Permitting and Inspections Department
Michael A. Russell, MS, Director

CBL: 132 G021001
Located at: 70 LAWN AVE

Inspection Violations

Owner/Manager FLANDERS SCOTT D		Inspector Kevin Hanscombe	Inspection Date 2/15/2018
Location 70 LAWN AVE	CBL 132 G021001	Status Violations Exist	Inspection Type Legalize Nonconforming units

### 3rd Floor

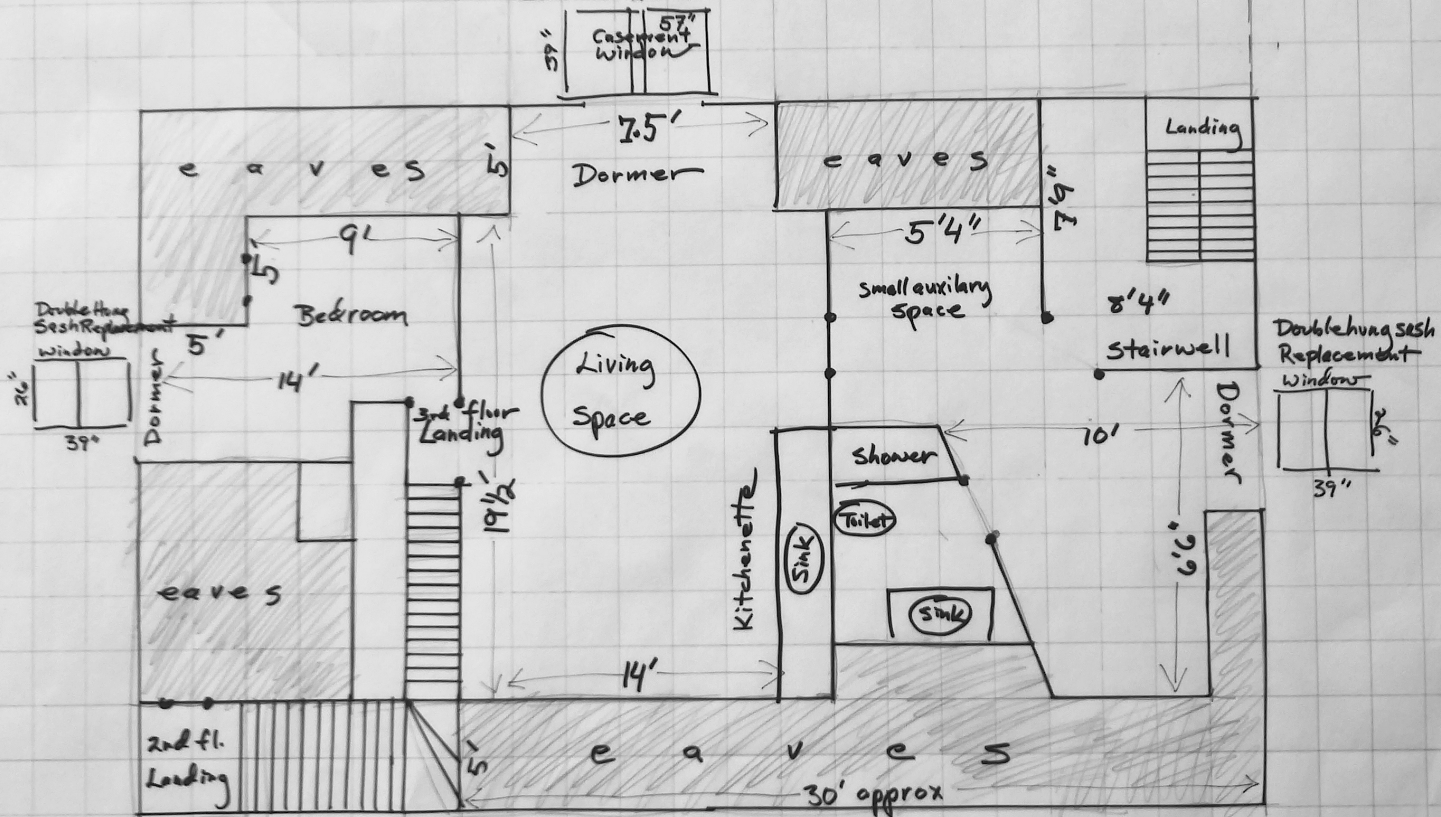
Notes: 3rd floor bedroom

Notes: "zoning violation" Though not being currently used as such the 3rd floor has become its own dwelling unit.

Comments: "Zoning" You have stated that the current real use if that the 3rd floor is part of the 2nd floor rental and is not being used as its own dwelling. To remove the 3rd floor "separate" dwelling and combine the 3rd floor as an extended living space with the 2nd floor the kitchen must be removed (sink with plumbing closed off at wall, refrigerator removed, counter top and cabinets removed). Additionally, as discussed during our inspection the separation must be removed by removing the now current separate entry doors going into both units on the 2nd floor front hallway. You may install one entry door at the top of the stairs and again as discussed this will allow free and open access between the 2nd and third floors.
